The Member Secretary,  
Chennai Metropolitan  
Development Authority,  
No.1, Gandhi Drive Road,  
CHENNAI -600 004.

Letter No. 12/17726/2023

Sub: CMDA - Planning permission - Proposed const-  
ruction of Factory Building at Plot No.82 &  
83, S.No.8/1A/B and 8/1B of Parangudi Village -  
Development Charges and other charges to be  
submitted - Regarding.

OWNER/POWER AGENT

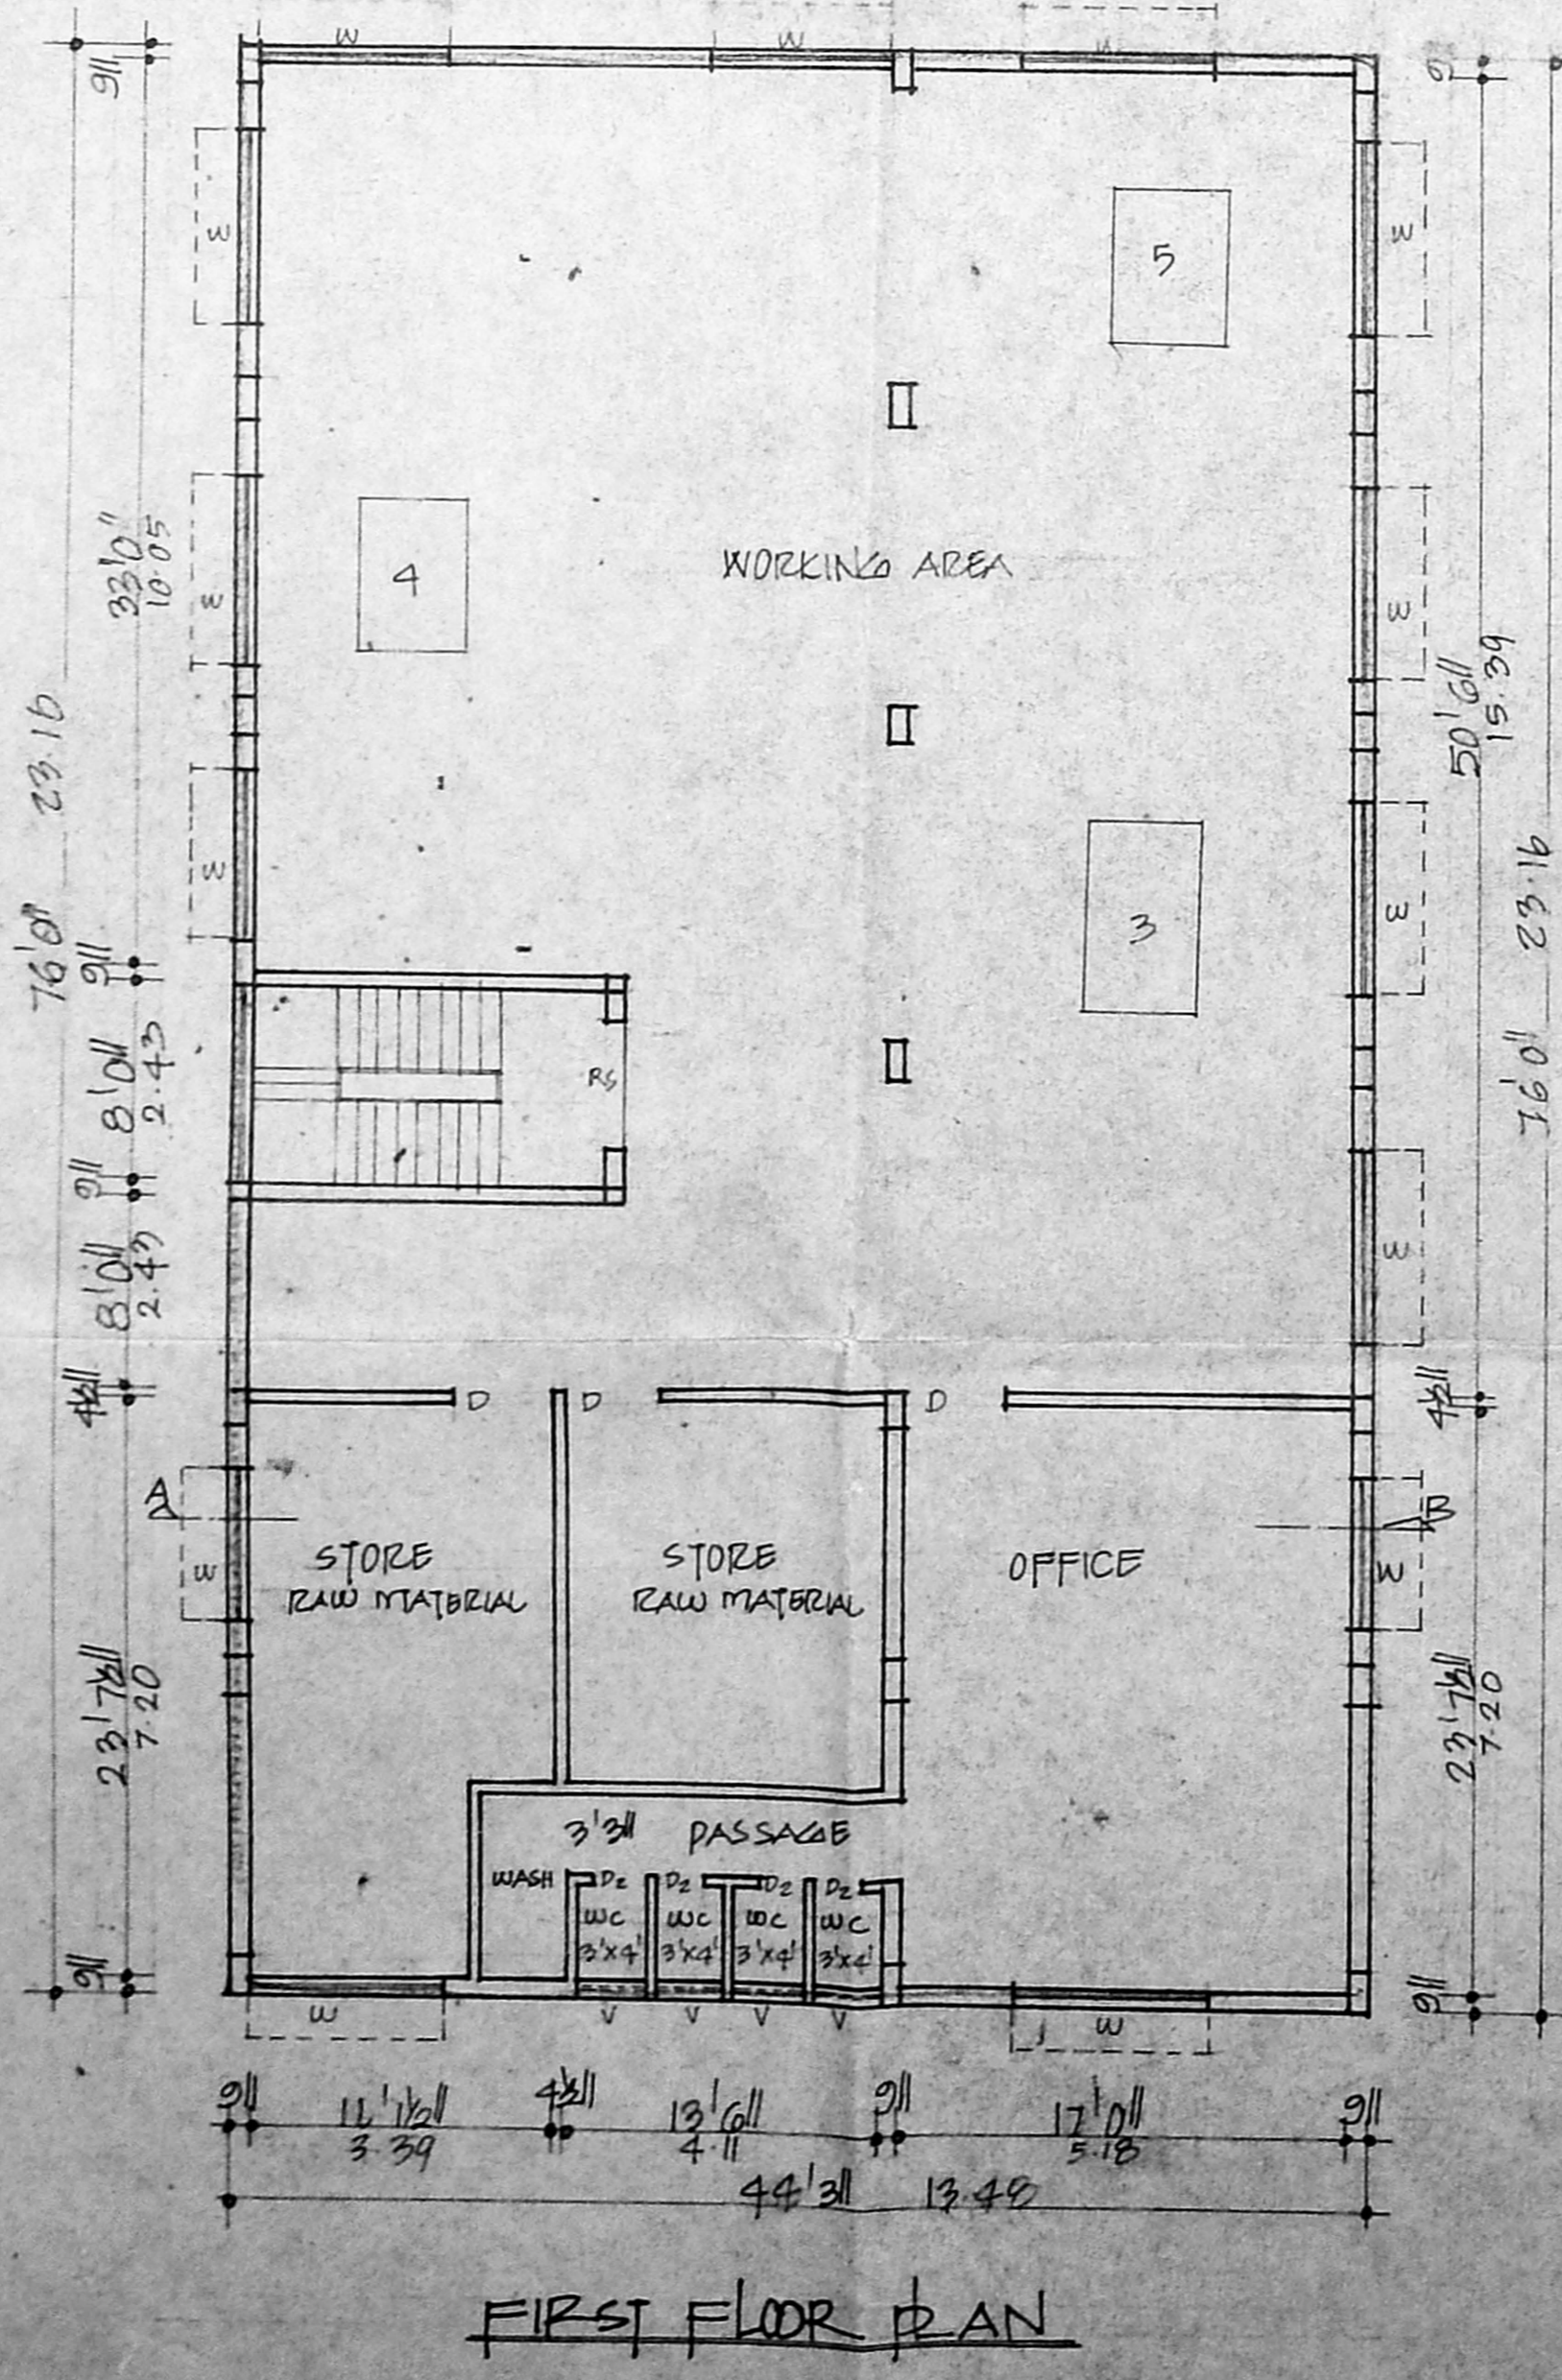
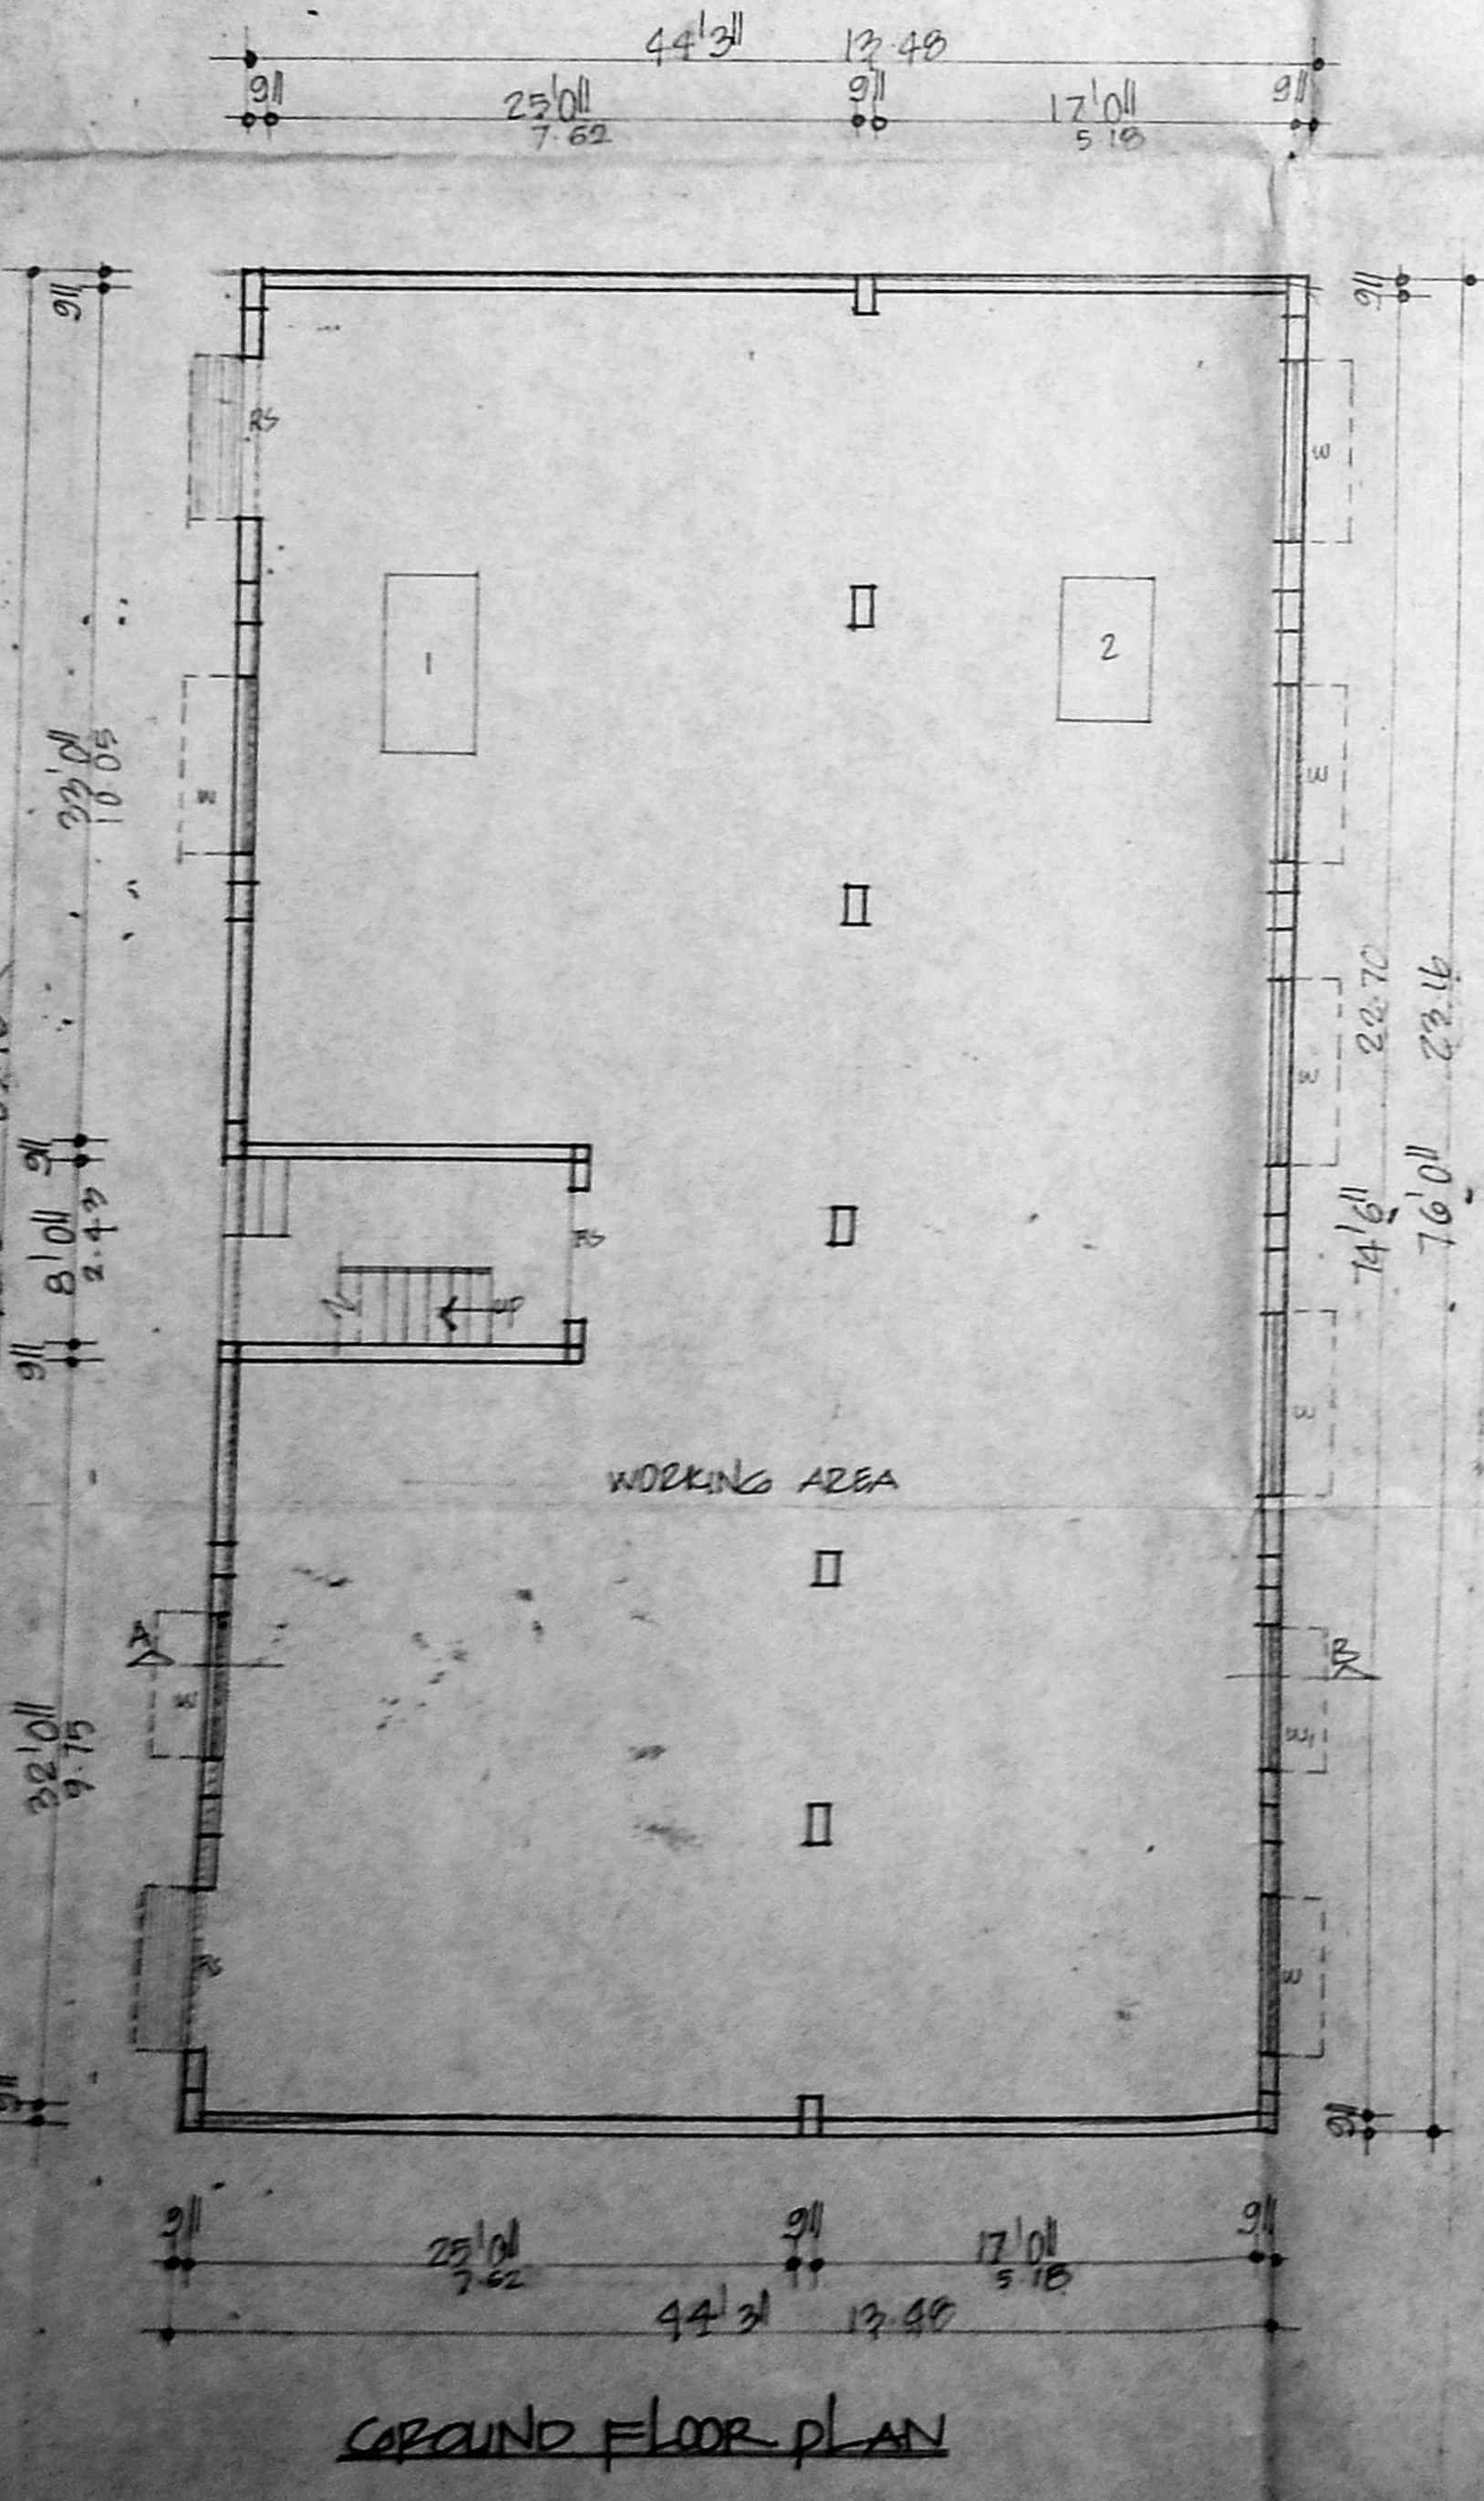
- a) Rain water conservation measures notified by CMDA should be adhered to strictly.
- b) Revised plans restricting Floor Space Index to 1.00 (least extent as per plan).
- c) Valid Tamil Nadu Pollution Control Board consent letter (latest) for the site under reference i.e. Survey No. 4/1A/B and 4/2A.
